From: Planning
Subject: FW: Lower Reaps Farm Whinney Lane Mellor - Planning Application (3/2022/0727 and 3/2022/0729)

In relation to the above planning applications, we raise no objections.

Drawing Title  
Proposed Barn  
Floor Plans and Elevations

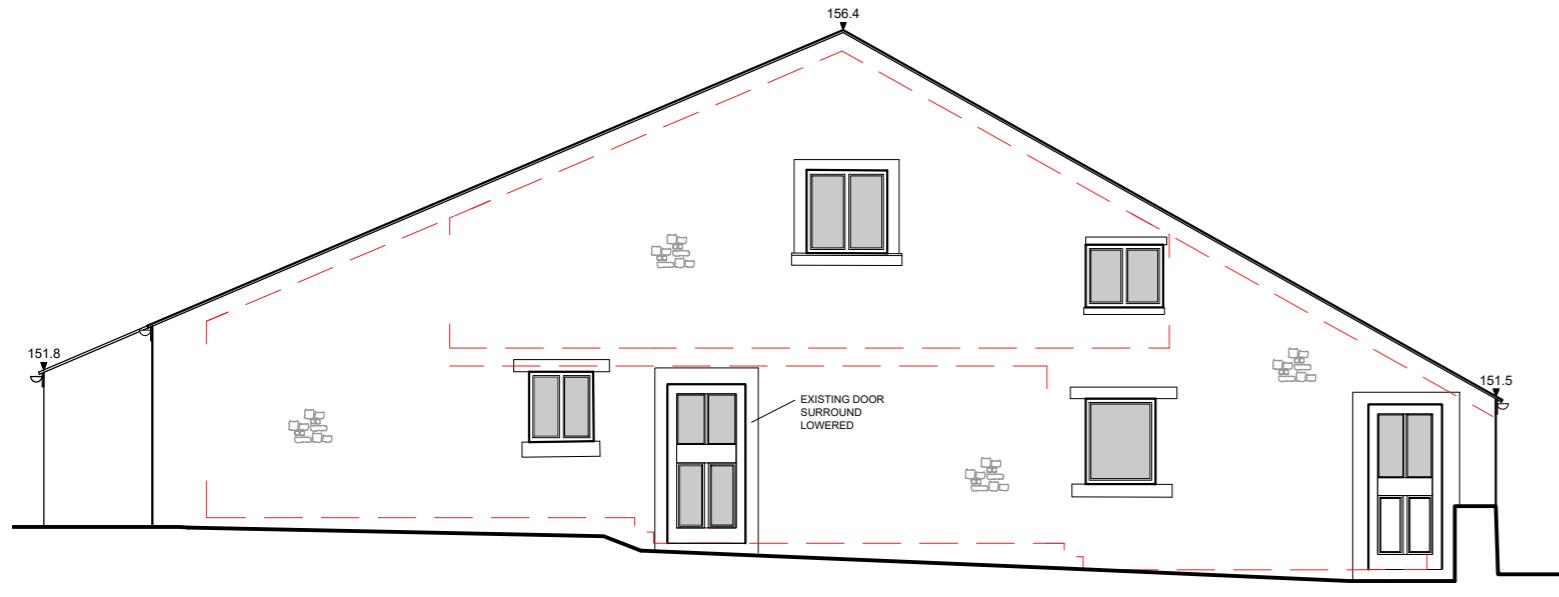
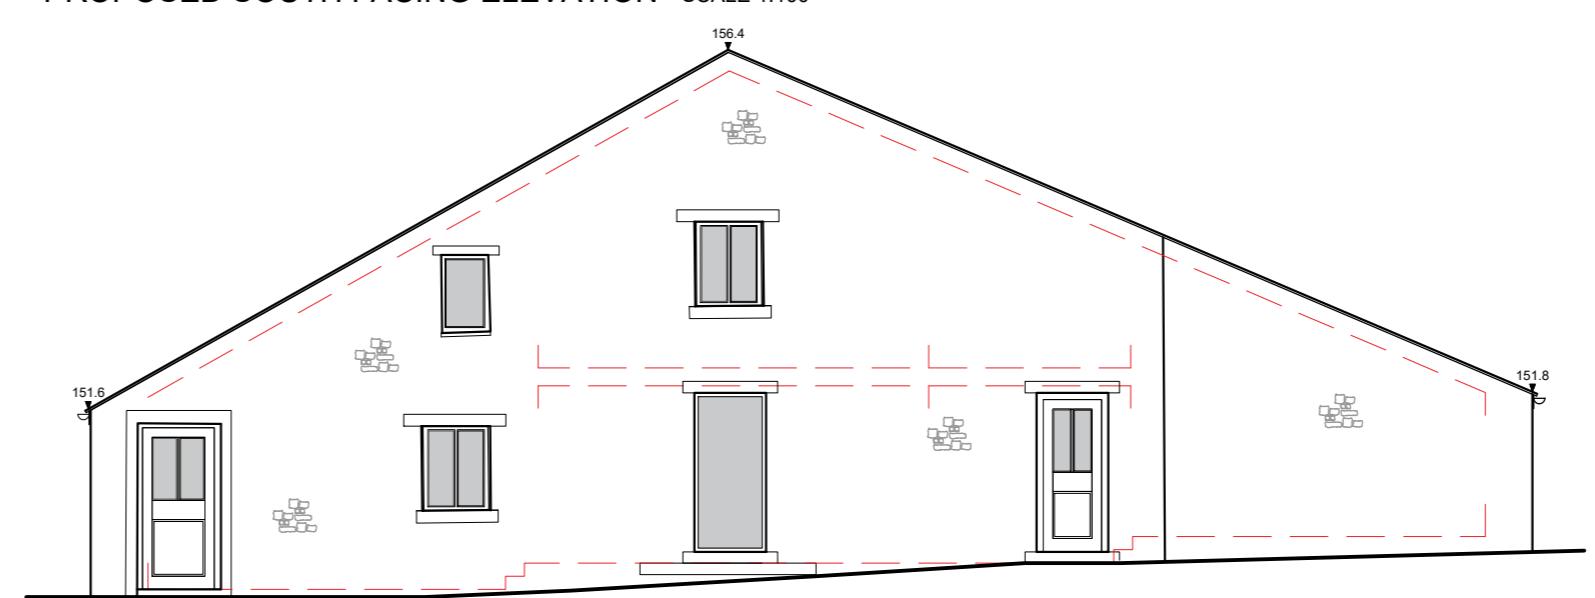
Improvements could likely be made to the window arrangement proposed for the barn conversion. Landscaping should also be used to break up the areas of hardstanding given their extent.
